Recommendation Report for Planning Permission

REF NO: **WA/57/17/PL**

LOCATION: 1 & 2 Stafford Cottages
 Yapton Lane
 Walberton

PROPOSAL: Conversion of 2 No. flats into 1 No. dwelling with two storey front & rear extension (resubmission following WA/25/16/PL).

| DRAWING NUMBER 15200/02R8                                                                         |                      |    |          |

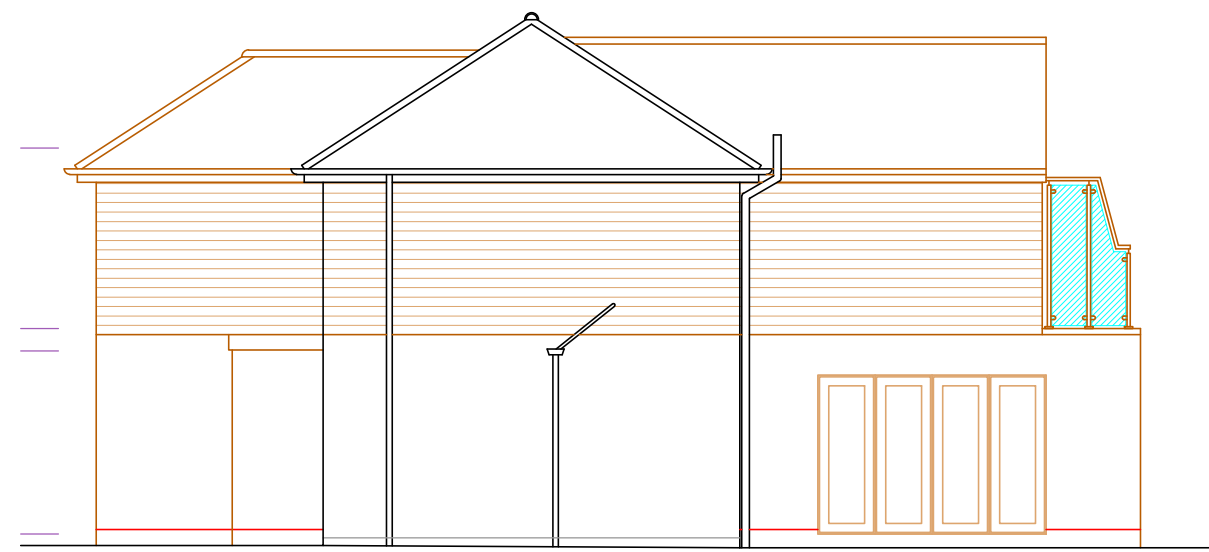
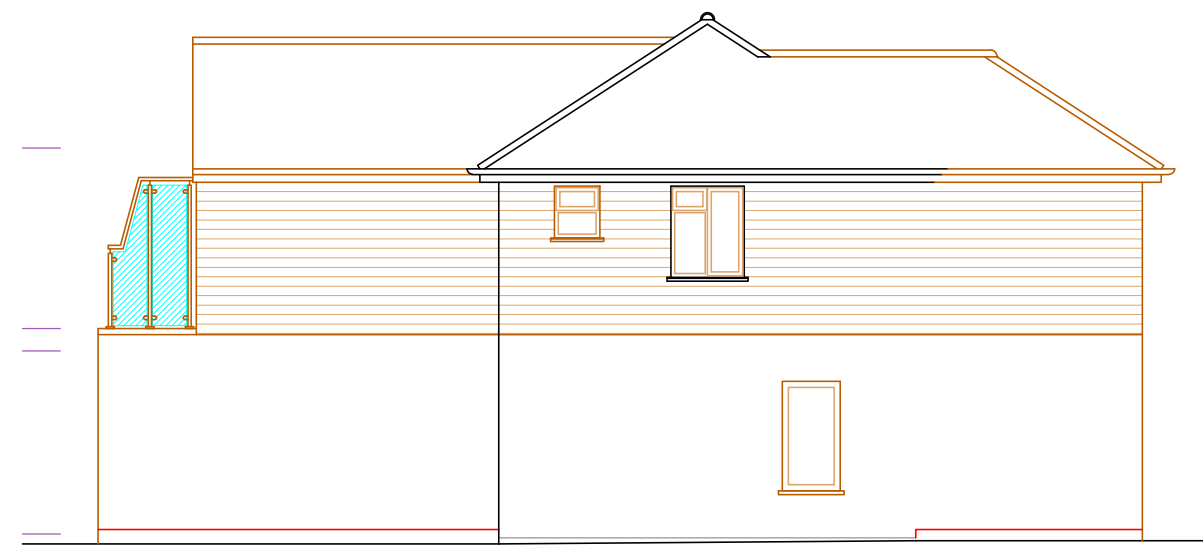
Objection - The modesty panel does not meet the conditions imposed by application WA/25/16/PL.

One Objection - The proposal does not protect neighbour's privacy from overlooking. Application WA/25/16/PL protected neighbour's privacy by the balcony being fully inset within the first floor walls. The scheme was amended. The walls were removed and neighbours' privacy was protected by a floor-to-ceiling, obscured glass screen which extended to the extreme edge of the western wall. The balcony was a uniformly flat surface with screens and a western balustrade fixed to the floor. The screening to the side elevations of the balcony was conditioned to ensure no direct overlooking resulted to adjoining gardens.

What has actually been built is a low wall around the balcony, not shown in any of the drawings in WA/25/16/PL or WA/57/17/PL. Attached to this wall is a staircase-style, pipework banister/balustrade with glass panels held in place by long clips. The horizontal rail on the western elevation is carried round the corners to continue some way into the northern and southern elevations, before rising diagonally to ceiling height. The effect of this is that anyone leaning on the horizontal rail can see clearly into the northern and southern neighbours gardens. The glass panels have large gaps of several inches surrounding them and the framework itself is set out from the western wall, leaving significant gaps. These are not privacy screens, they are just decorative panels. It is easy for people on the balcony to see over and through the balustrade. During the building work, both neighbours experienced workmen calling to them from the balcony.

Whilst the design of the balcony screening has altered from that approved it is not considered to result in any unacceptable additional material loss of privacy to neighbouring properties to warrant refusal. The revised screen projects further than the original design. It cannot easily be looked through between the narrow upright slits or to the side. The agent has advised that the gap between the vertical posts and glass is approximately 22mm. The balcony is not of significant depth and anyone seated would not be able to readily look over the side balustrading.

Given the previous approval the only matter that can be considered as part of this proposal is the impact that the change in design of balcony screening has on neighbouring residential amenity. The balcony sides are constructed of panels which have a gap of approximately 22cm between them and the supports. The end panels also have a different shape. The previous profile was curved, dropping from 2m to 1.1m at a distance of approx. 20cm from the rear elevation. This proposal extends the projection from the rear elevation at 2m height to 70cm before dropping to 1.1m. The extent of screening is therefore greater in this application, albeit that there are gaps in the screening. It is therefore considered that the application is acceptable in terms of impact on residential amenity from over looking. Conditions relating to the provision and retention of obscure glazing to the balcony are suggested.

- 2 The obscure screening to the balcony hereby approved and indicated on the submitted plans shall be retained in perpetuity.
